ATTENTION: Director – Social and Infrastructure Assessments

Submission for SSD-8996 Loreto Normanhurst School.

Redevelopment (Concept Proposal Stage 1)

Ray and Freda Oslington

2 SITE ELEVATION - MOUNT PLEASANT AVENUE
1:500

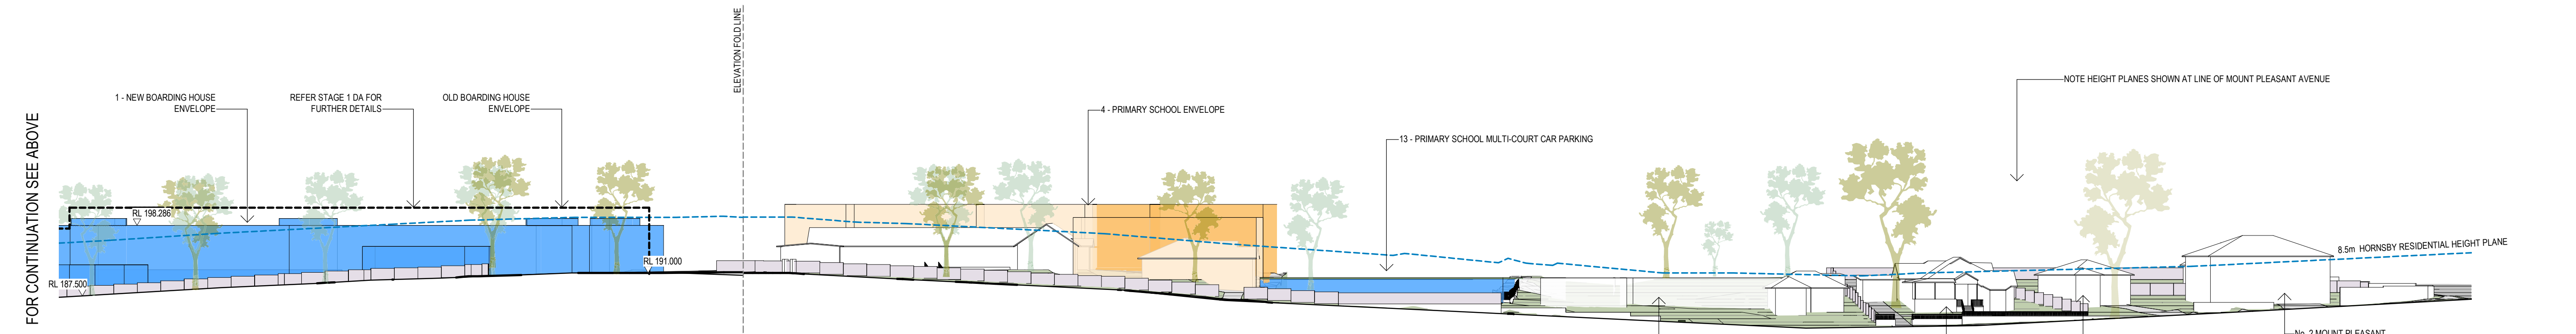
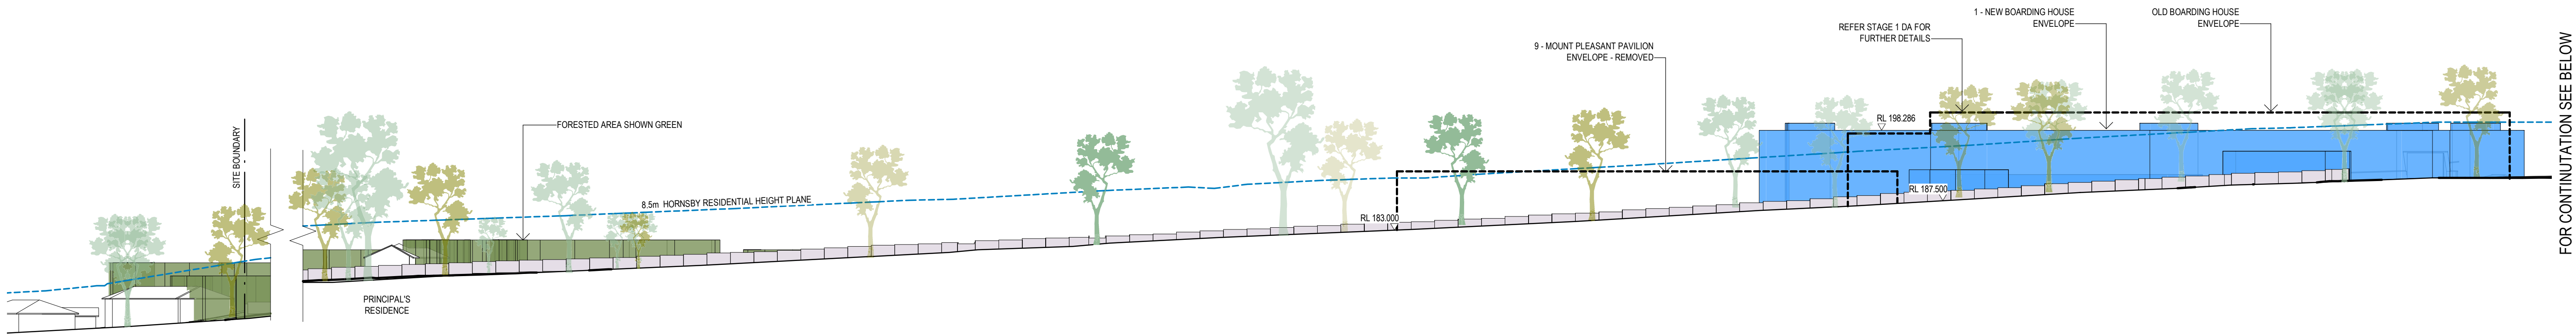
TWO. Frankly the streetscape of the boarding school as viewed from Mt Pleasant Avenue is ugly, and its height and closeness to the street make it even less appealing. Perhaps consideration could be given to positioning it further from the street with lawns, gardens and trees planted to give a more pleasant aspect.
